Addendum No. 1

RE: Contract ID C203080

Madison County (formally B-4182)

Bridge #246 Over Laurel Creek On SR-1503

STATE OF NORTH CAROLINA
 DEPARTMENT OF TRANSPORTATION
 RALEIGH
 DOUBLE 12 FT. X 7 FT.
 REINFORCED CONCRETE BOX
 CULVERT
 150° SKEW

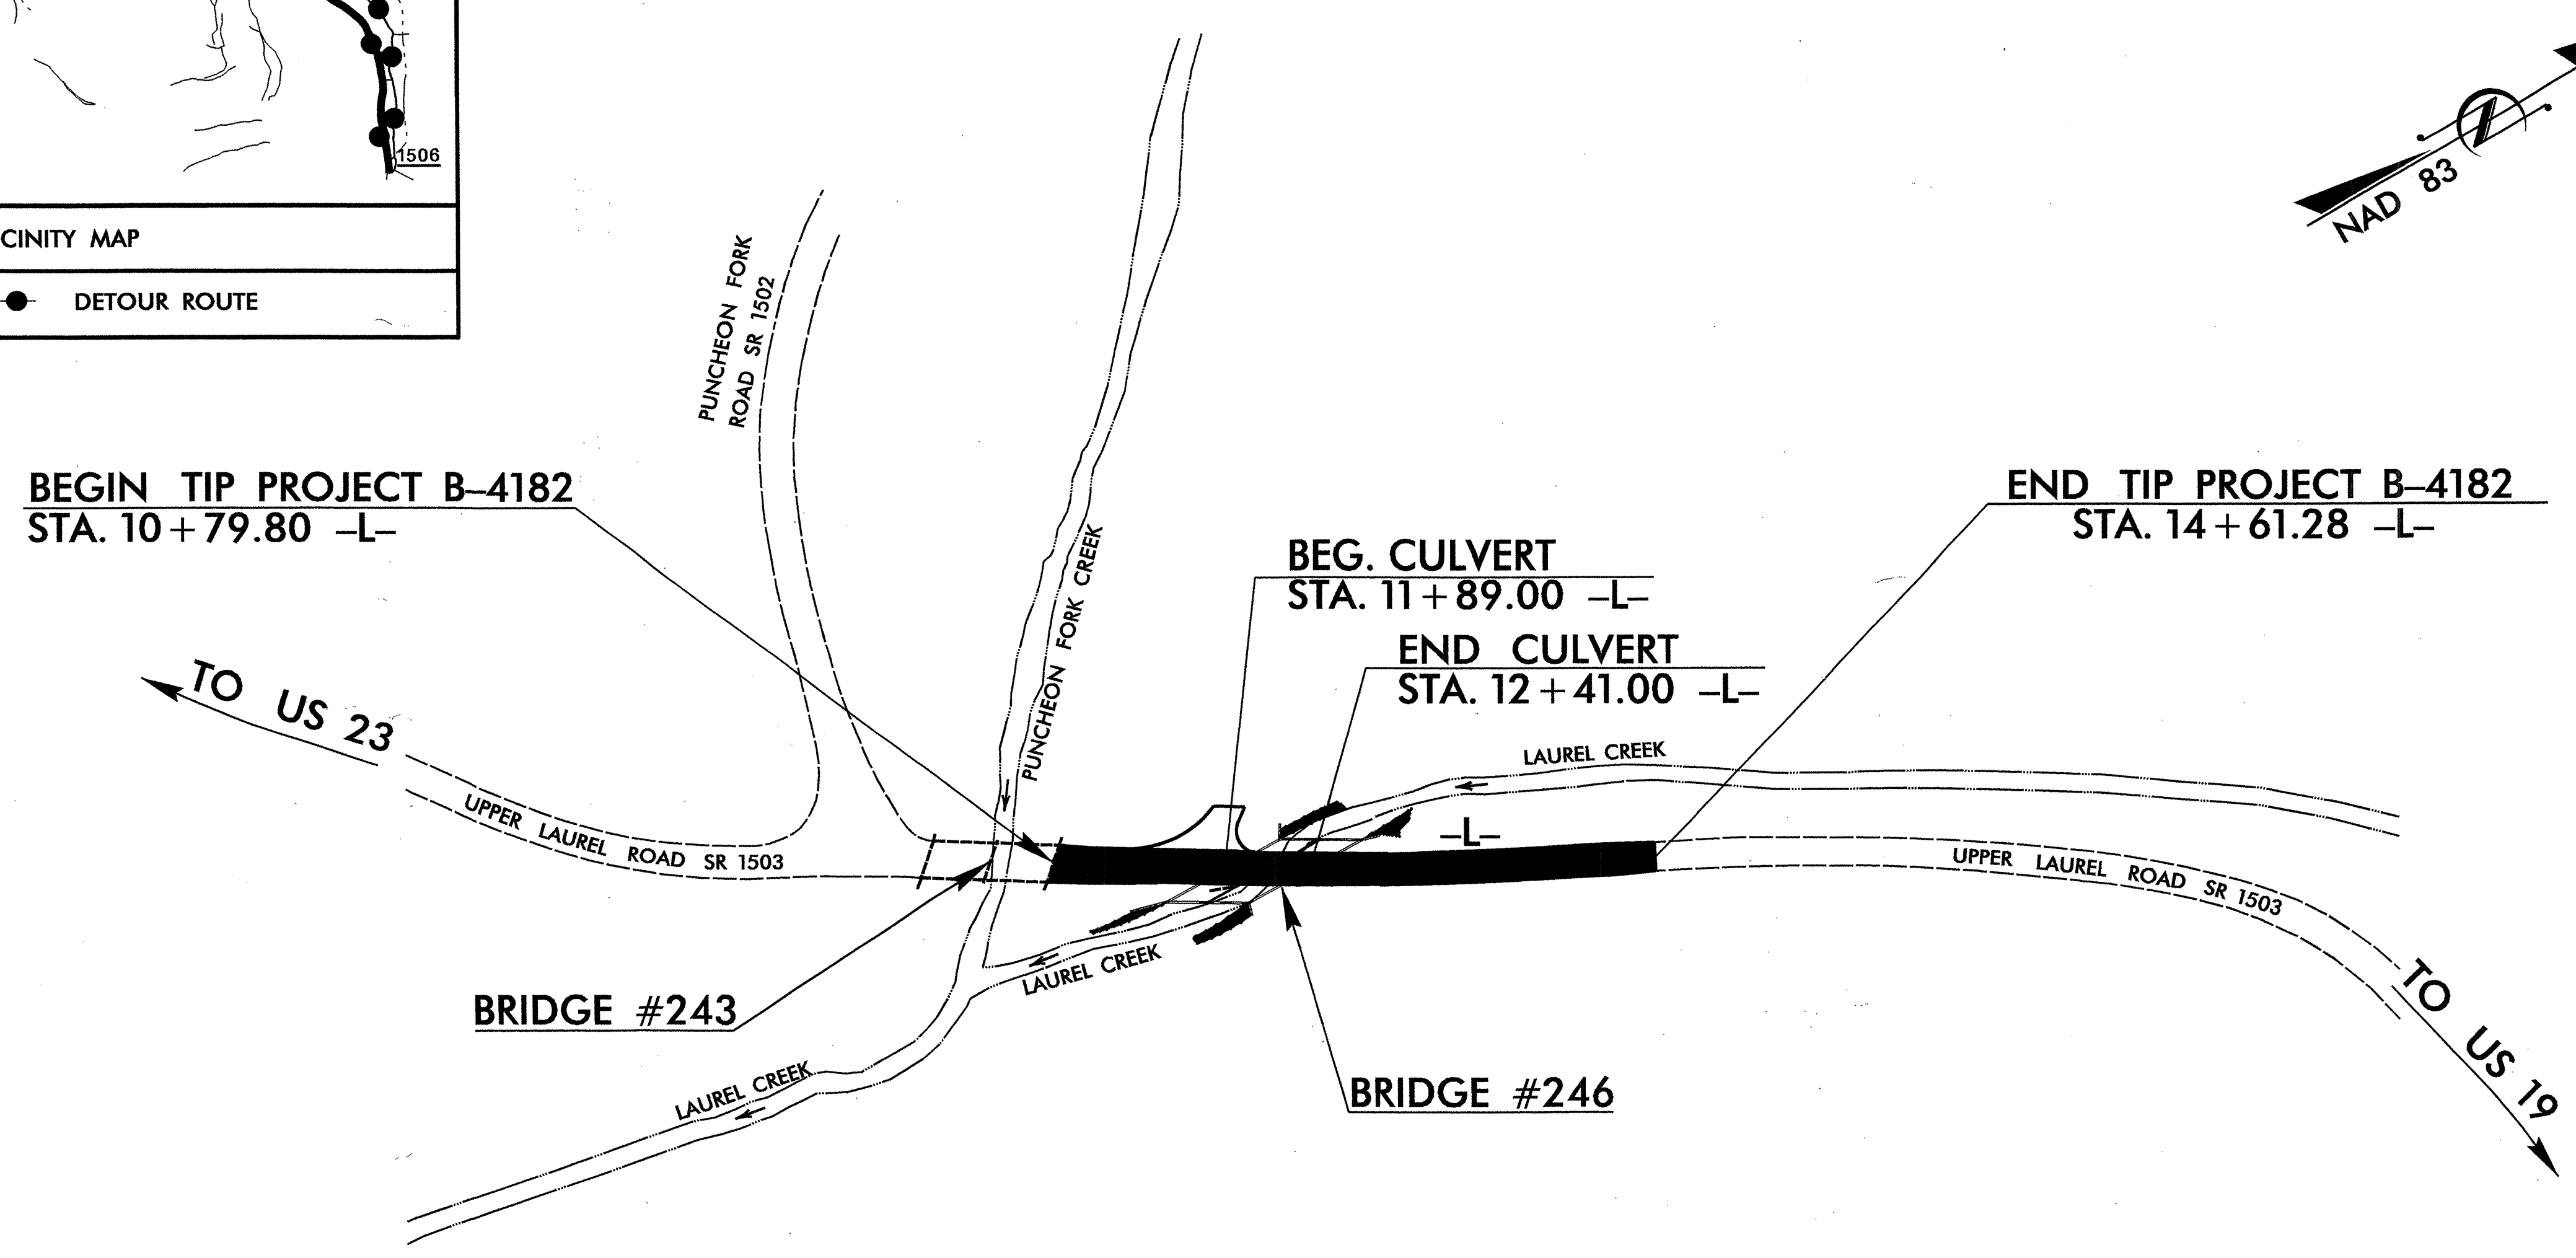
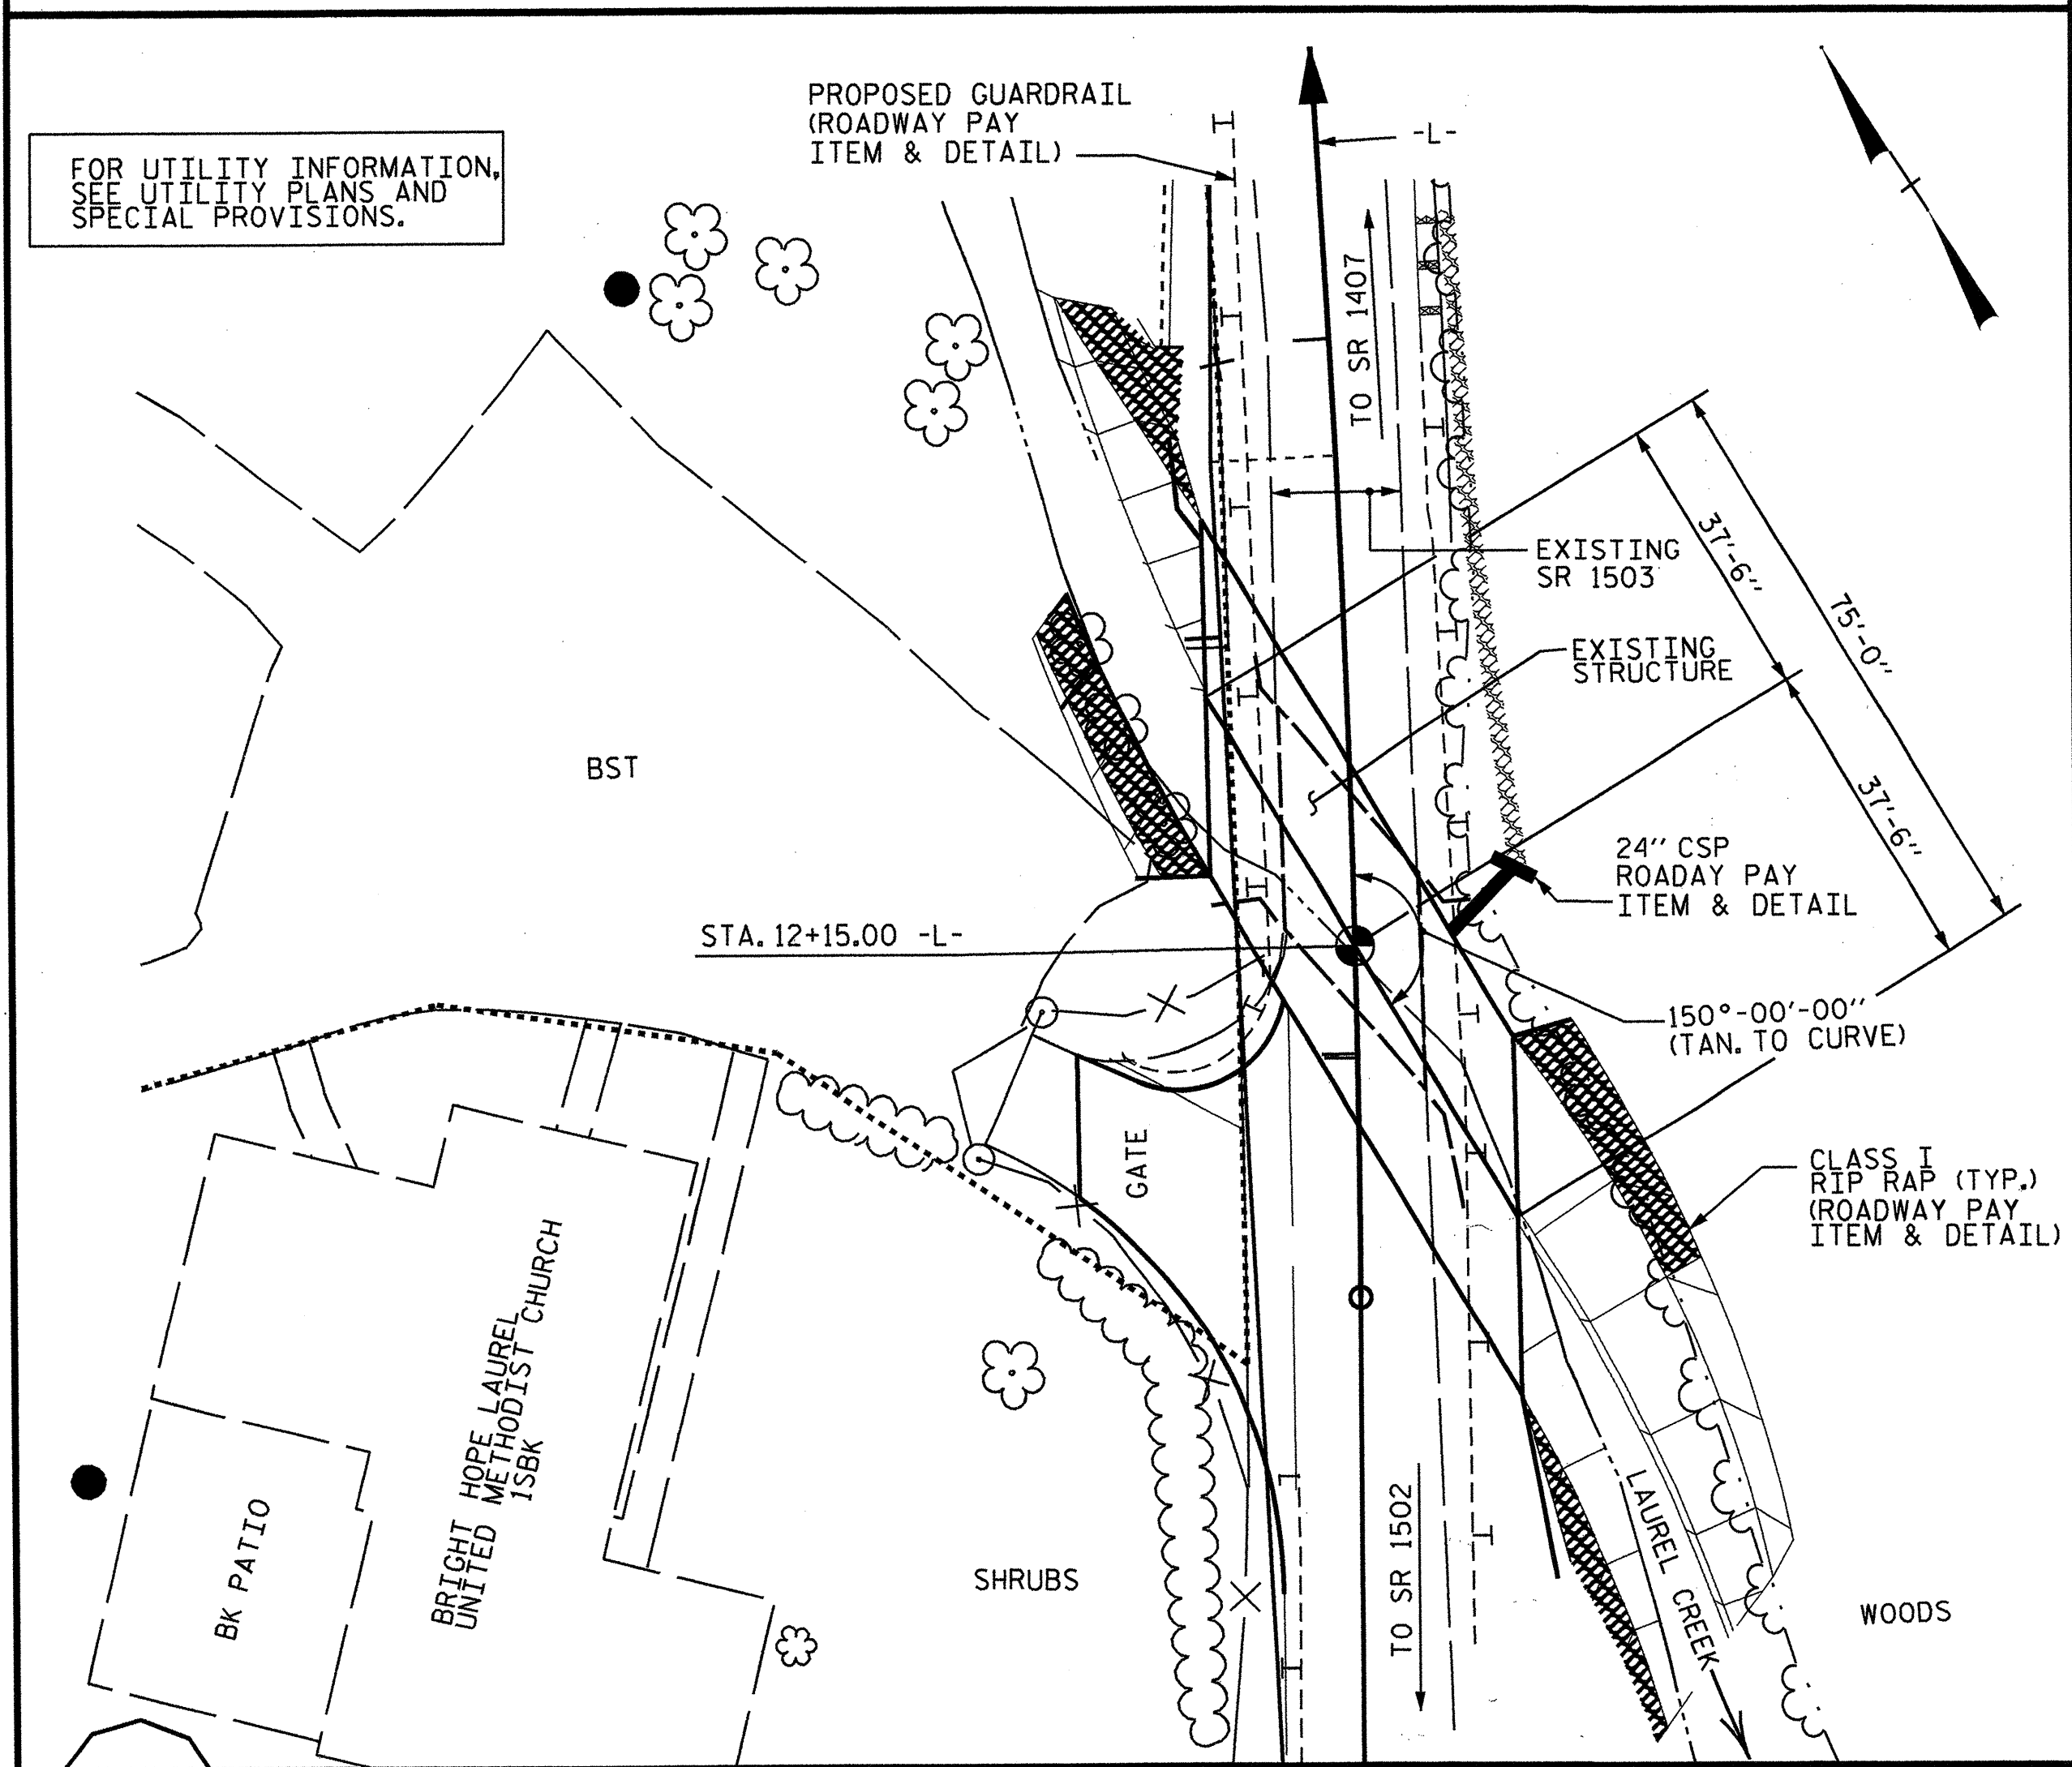
On the item sheets the following pay item quantities have been revised to agree with the plans:

<u>Item</u>	<u>Description</u>	<u>Old Quantity</u>	<u>New Quantity</u>
74-8133000000-E-414	Foundation Conditioning Material, Box Culvert	139 TON	138 TON
75-8196000000-E-420	Class A Concrete (Culvert)	241.1CY	238.2 CY
76-8245000000-N-425	Reinforcing Steel (Culvert)	29,672 LB	29,719 LB

The Contractor's bid must be based on these revised pay item quantities. The contract will be prepared accordingly.
